Letter No. A1/15004/03

Sub: CMDA - Planning Permission - Construction of **Ground Floor**

Residential/Commercial Building at Plot No.16, M.C.N. Nagar in
S.No.102/2 and 104/2A1A1D of Okkiyanthorai Pakkam

Plan showing the Proposed dwelling house at Plot no. 16, O.S. no. 102/2 & 104/2B N.S. no. 102/2 & 104/2B B.D, M.C.N Nagar, Oggiam Thorappakkam village, Saidapet taluk, Chingpet District

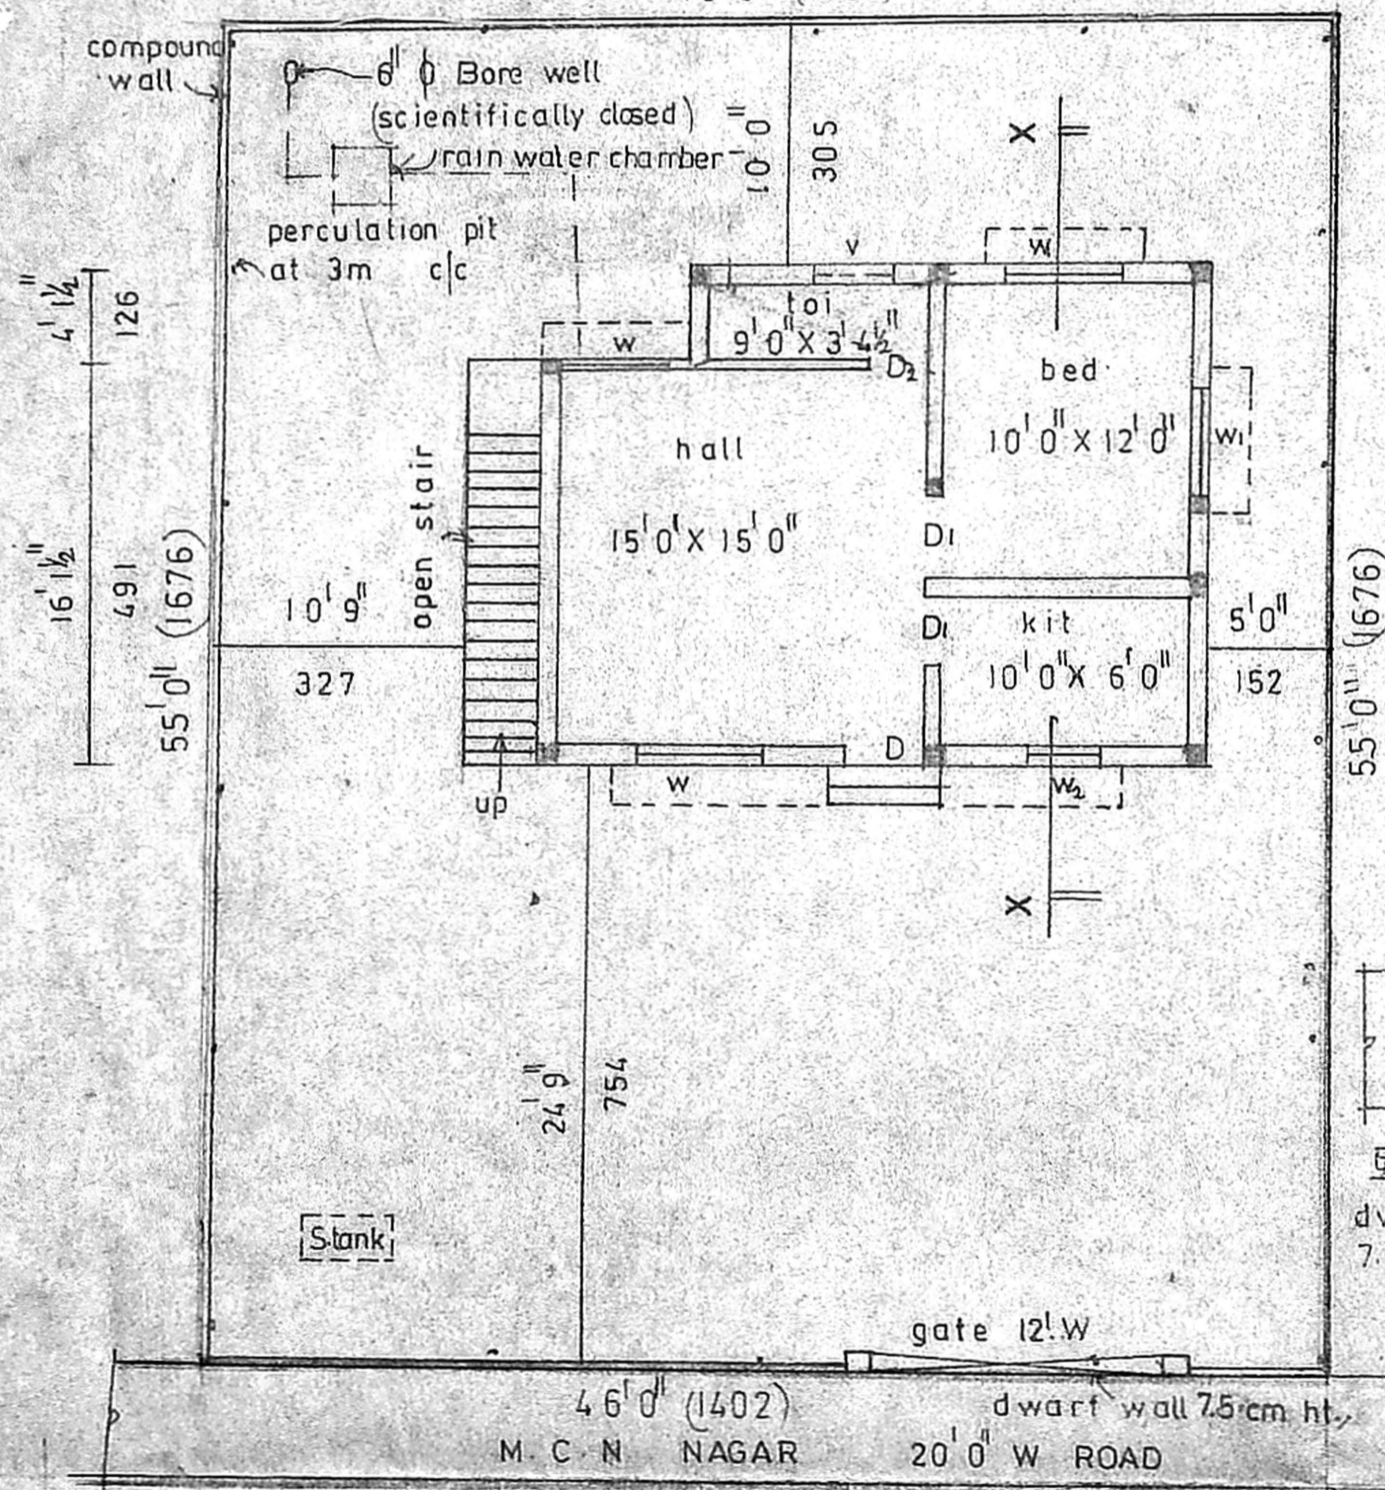
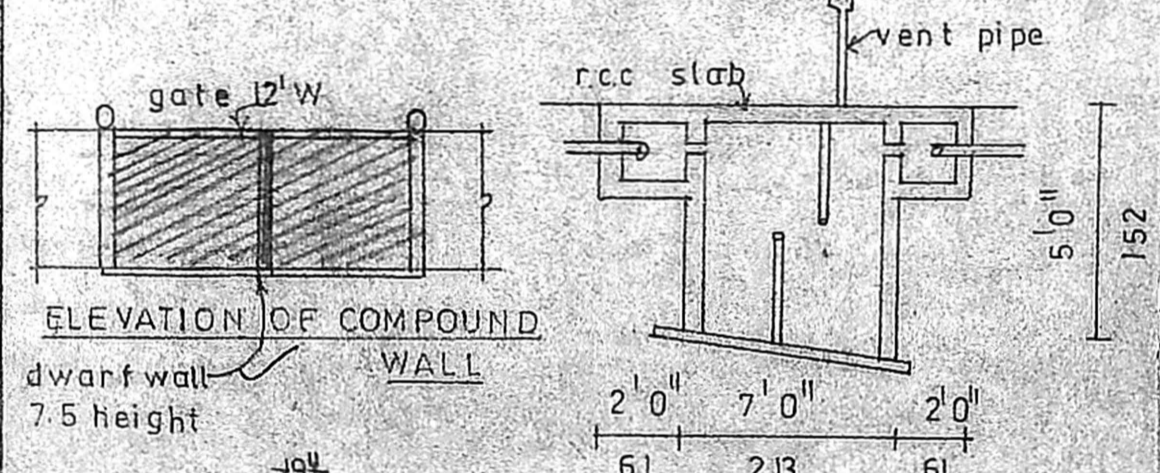
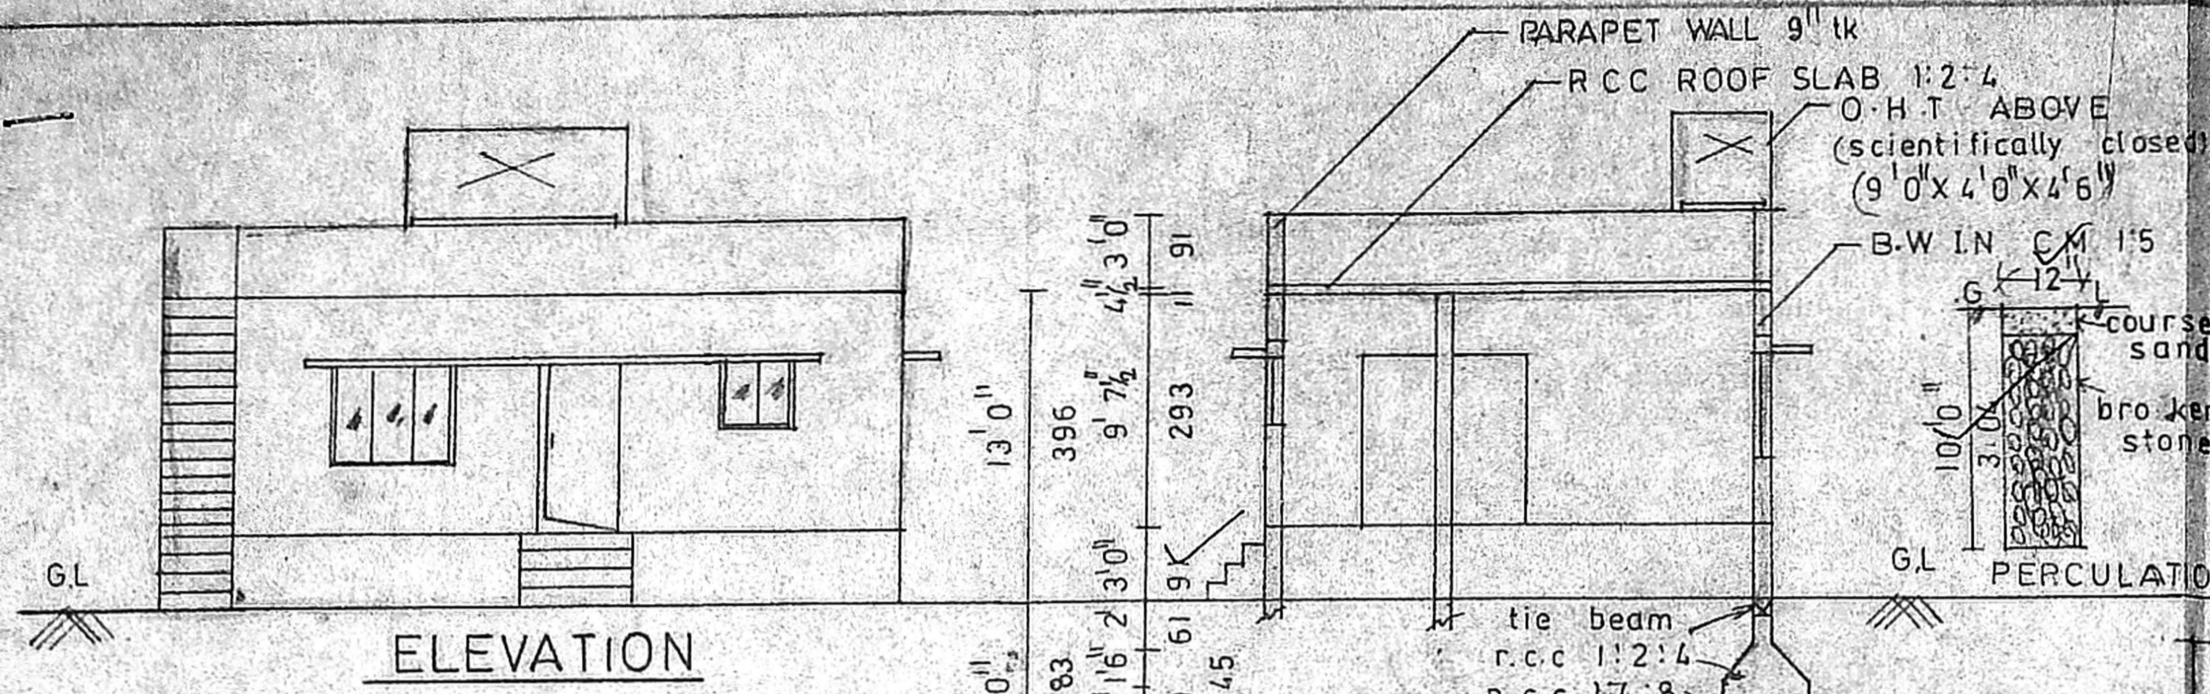
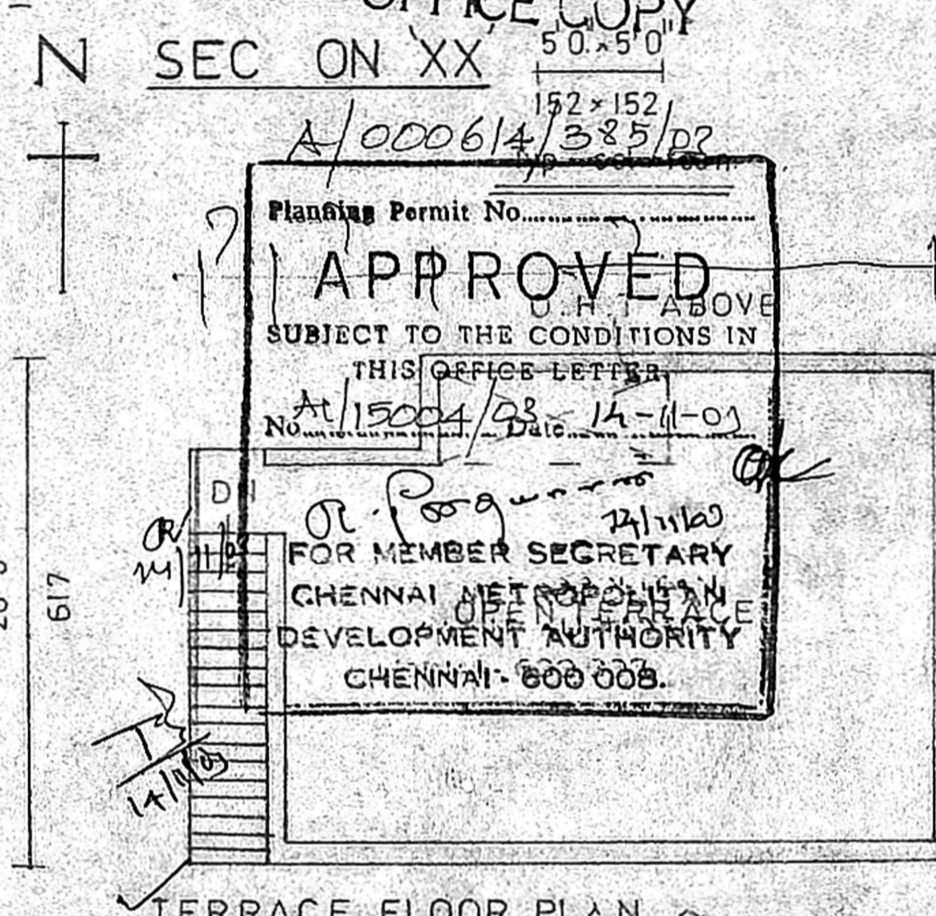
1. Terrace floor plan not shown.
2. Compound wall details/gate details with 7.5 cm height dwarf wall along gate not shown.
3. Rainwater harvesting pit width not shown.
